Our Ref: AB/136/19/L

Planning (Listed Buildings and Conservation Areas) Act 1990 (as amended)

Application for Listed Building Consent for Alterations, Extension or Demolition of a Listed Building

Development Proposed internal and external alterations to existing building at The Old Wheatsheaf, 31 Maltravers Street, Arundel, BN18 9BU including replacement of selected windows and doors and new ground floor terrace to provide more flexible family living accommodation and a lower ground floor annex.

2 Site Block Plan
Scale: 1:500

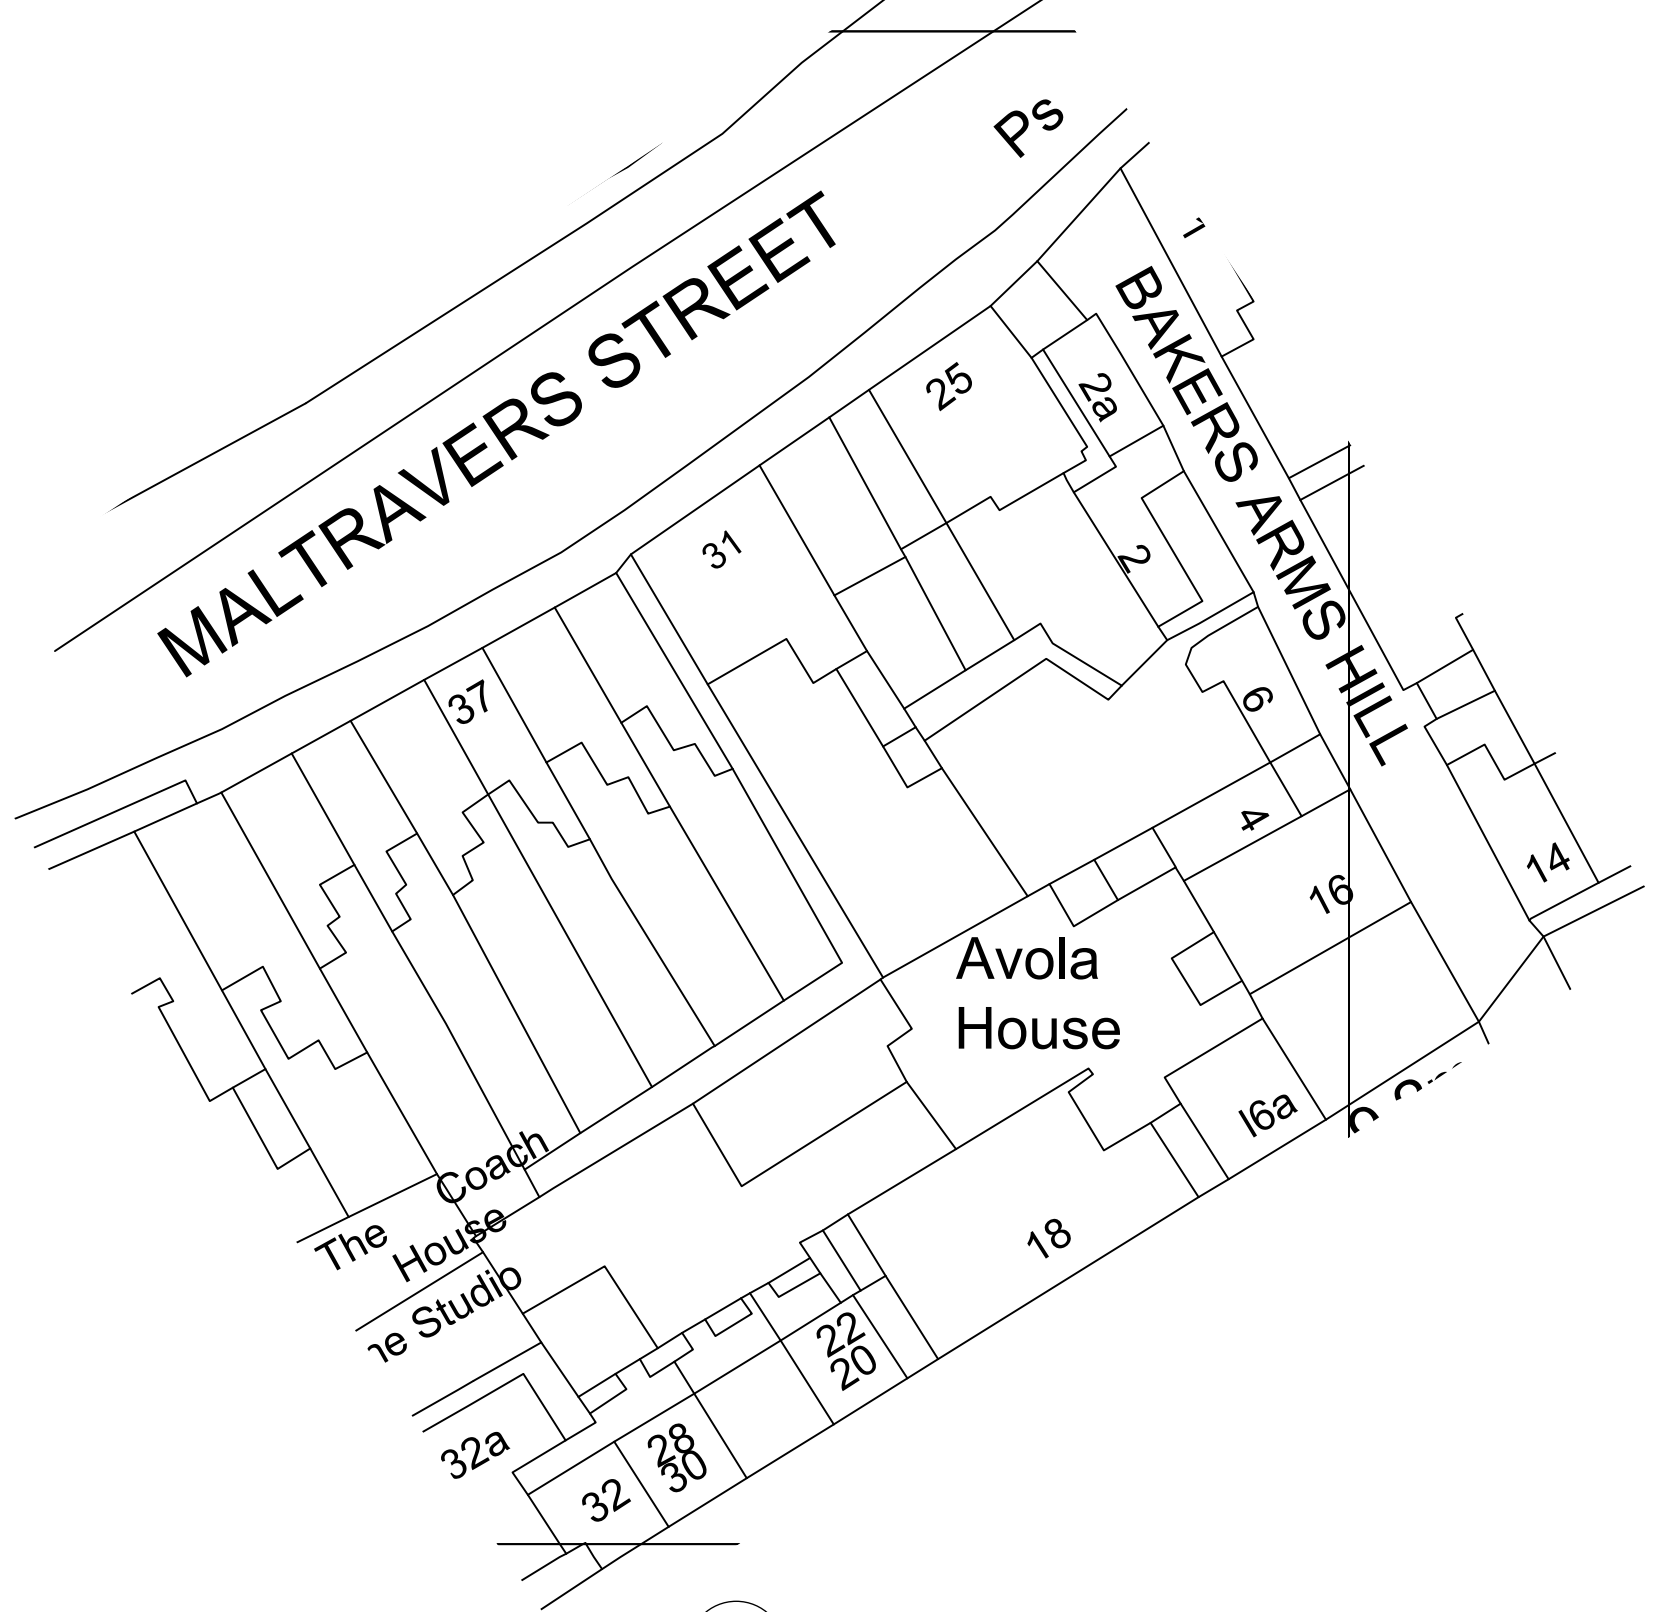
Dimensions: You are required to include dimensions on the block plan from the proposed extensions to all site boundaries.
